Application for a non-material amendment following a grant of planning permission.

TWO STOREY SIDE EXTENSION & SINGLE STOREY FRONT PORCH.

CHANGE TO REAR SINGLE STOREY ROOF FROM PITCH TO FLAT ROOF WITH 2M x 1M ROOF LIGHT.  
(THIS CHANGE DUE TO PITCH BEING TOO SMALL TO ALLOW FOR TILES).

Drawing Title:
Proposed Elevations

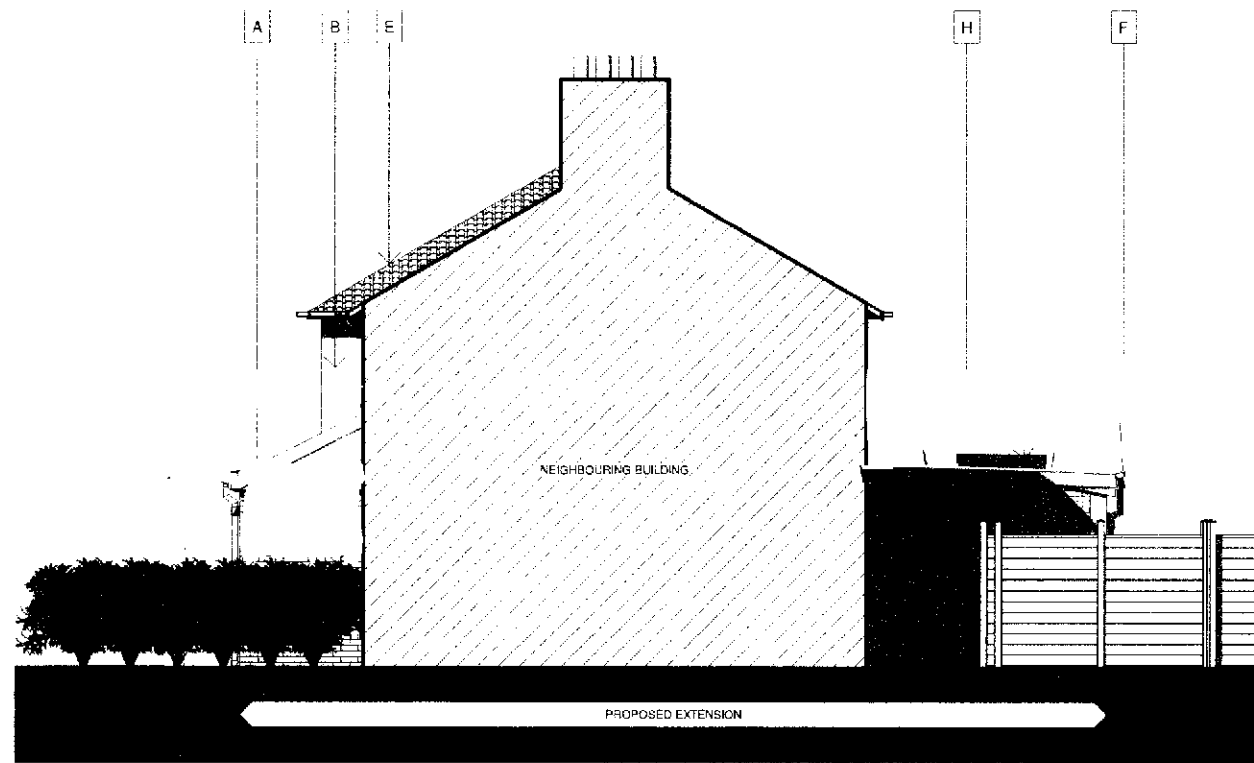
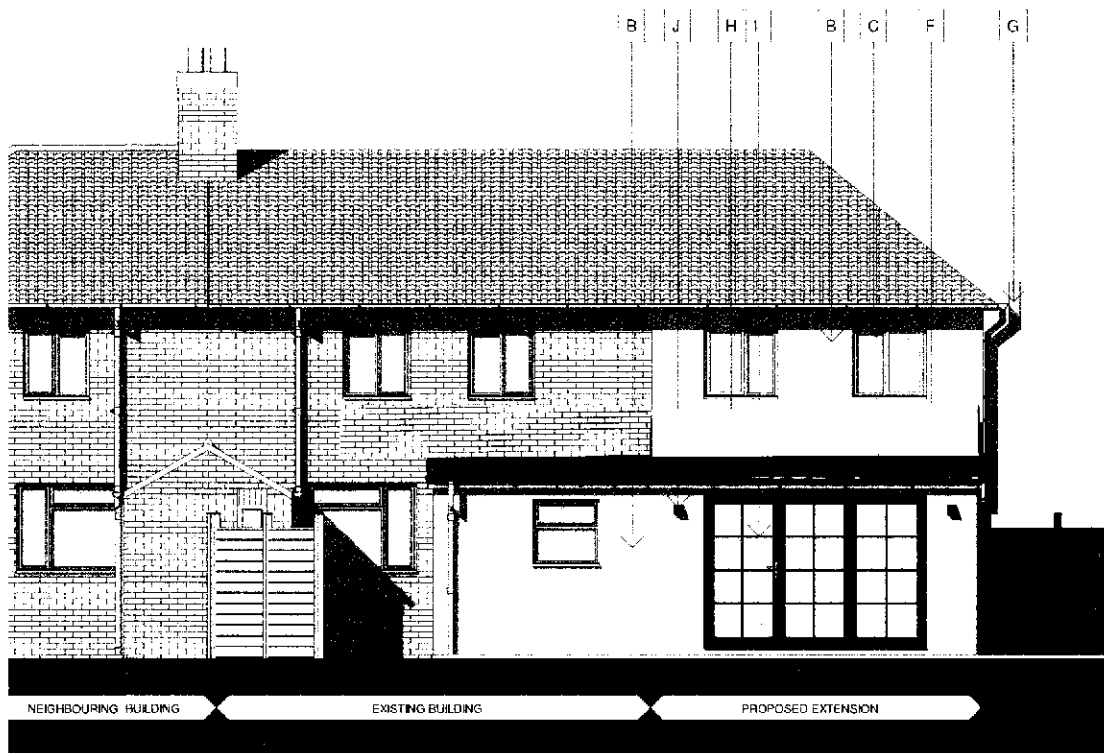
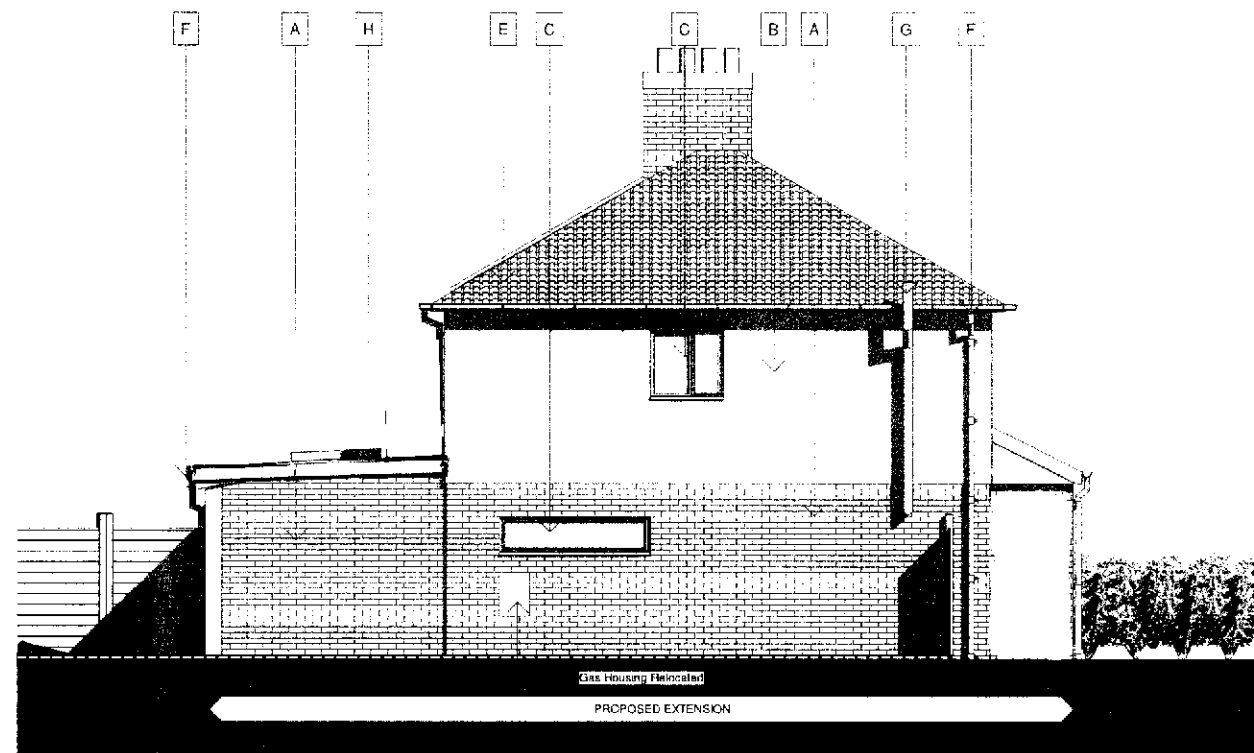
PITCH IS TOO SLIGHT TO ALLOW FOR TILED ROOF. SO FLAT ROOF TO MATCH EXISTING IS PROPOSED WITH FIXED ROOFLIGHT.
